Application Ref:	3/2025/0818			 Ribble Valley Borough Council www.ribblevalley.gov.uk
Date Inspected:	16/10/25	Site Notice:	N/A	
Officer:	LW			
DELEGATED ITEM FILE REPORT:				APPROVAL

Development Description:	Variation of condition 2 (approved plans) on planning permission 3/2010/0163 to substitute corten steel cladding to the balcony wall for the approved render finish.
Site Address/Location:	42 Painter Wood, Whalley Old Road, Billington, BB7 9JD.

EXISTING AND PROPOSED
ELEVATIONS FRONT

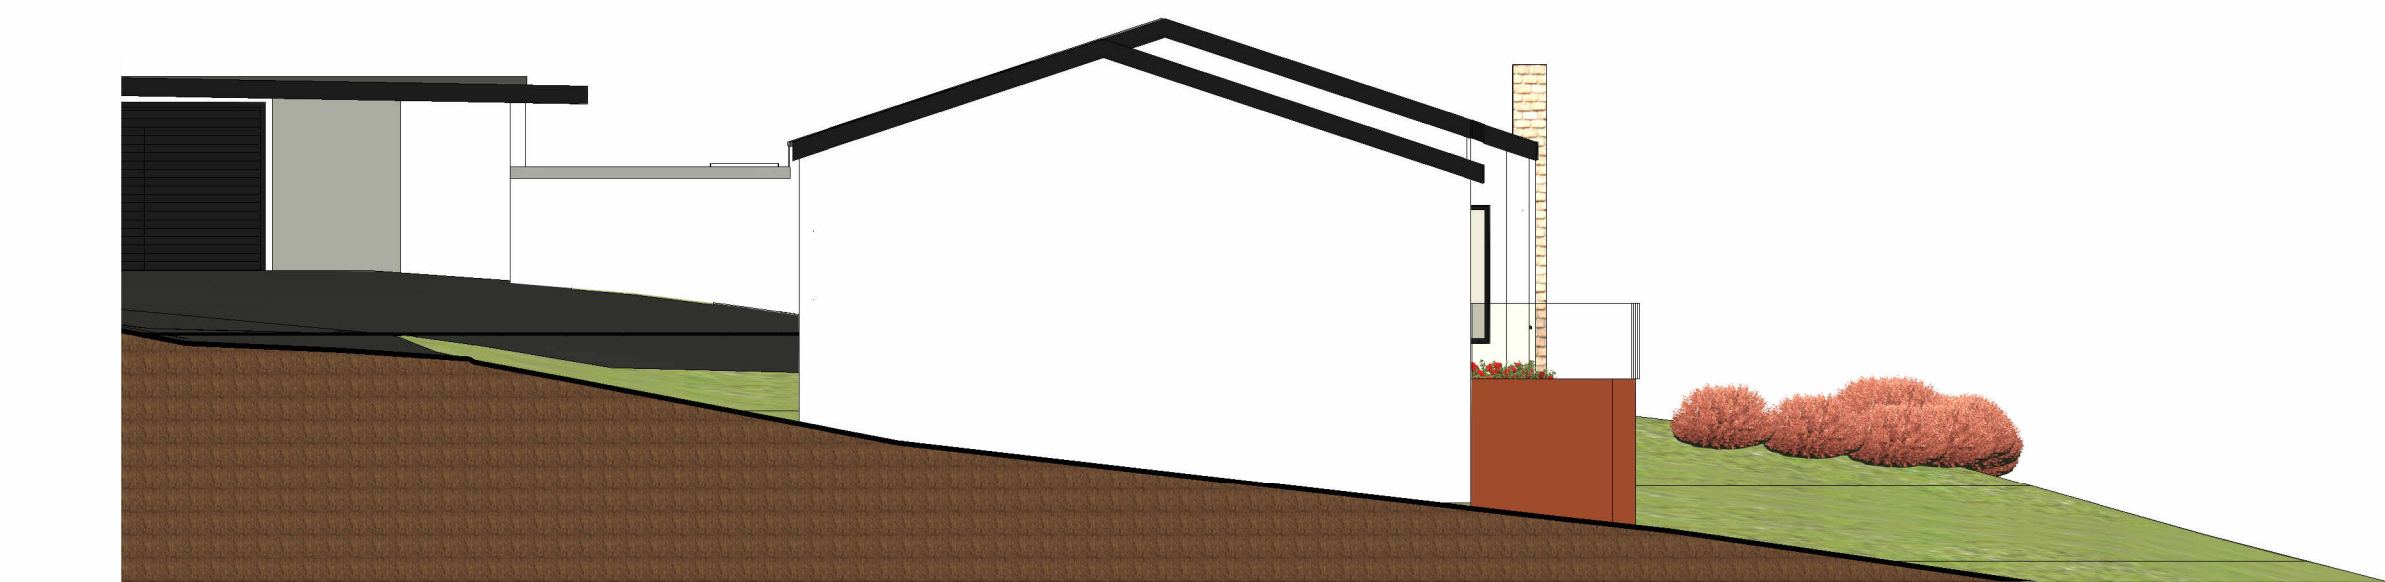
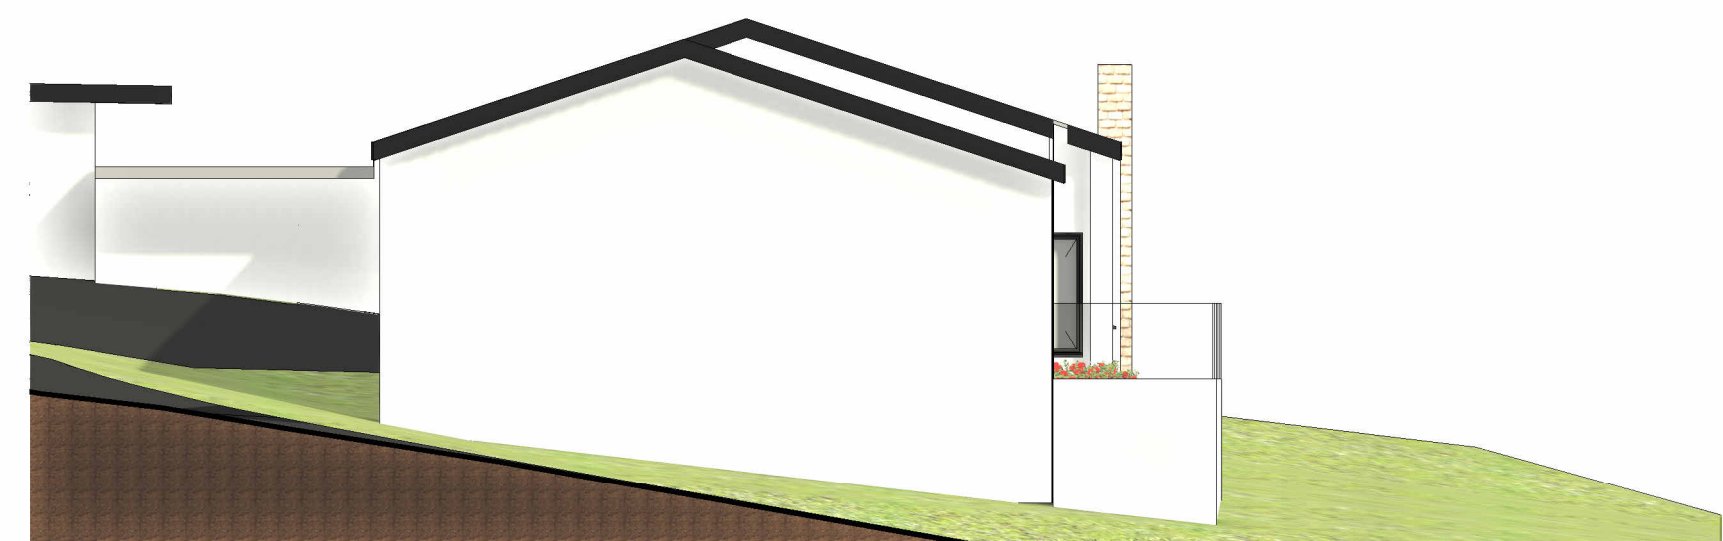
This application seeks consent for a variation to the design of the approved development with the revised scheme to include the replacement of the previously approved render to the balcony walls featured to the principal elevation of the dwelling with corten steel cladding.

Whilst the contemporary style of the application property and nearby built form is acknowledged, the principal elevation of the application dwelling comprises a mixture of white render, vertical timber cladding, horizontal charred timber cladding and stone. In this respect, the use of corten steel cladding would result in the introduction of an additional material/ colour to the principal elevation of the dwellinghouse which would appear neither sympathetic to nor reflective of the existing external facing materials featured to the front of the property. The proposal, if implemented, would thus result in the material palette of the property appearing overtly fussy, resulting in a diminishing quality of development, comparative to that of the approved. The impact of this would only be exacerbated by the prominent siting of the application property along Painter Wood, with the dwelling also occupying an elevated position when viewed from the highway. The proposed variation would therefore be directly visible from the adjacent public realm, resulting in a clear visual impact and being of detriment to the visual amenities of the immediate area

In an attempt to address these concerns during the determination of the application, the Local Planning Authority sought an amendment to the proposed variation, suggesting the use of timber cladding or an alternative type of steel cladding to better integrate with the existing materials featured to the principal elevation of the property. However, no amended plans have been received and the agent has requested that the application be determined based on the plans originally submitted with the application.

Taking account of the above, the proposal is considered to be in direct conflict with the Policy DMG1 of the Ribble Valley Core Strategy and Paragraph 140 of the National Planning Policy Framework insofar that approval would result in a diminished quality of development comparative to that of the approved, resulting in a form of development that would be of detriment to the visual amenities of the immediate area.

The proposal is considered to be in direct conflict with Policy DMG1 of the Ribble Valley Core Strategy and Paragraph 140 of the National Planning Policy Framework insofar that approval would result in a diminished quality of development, comparative to that of the approved, resulting in a form of development that would be of detriment to the visual amenities of the immediate area.
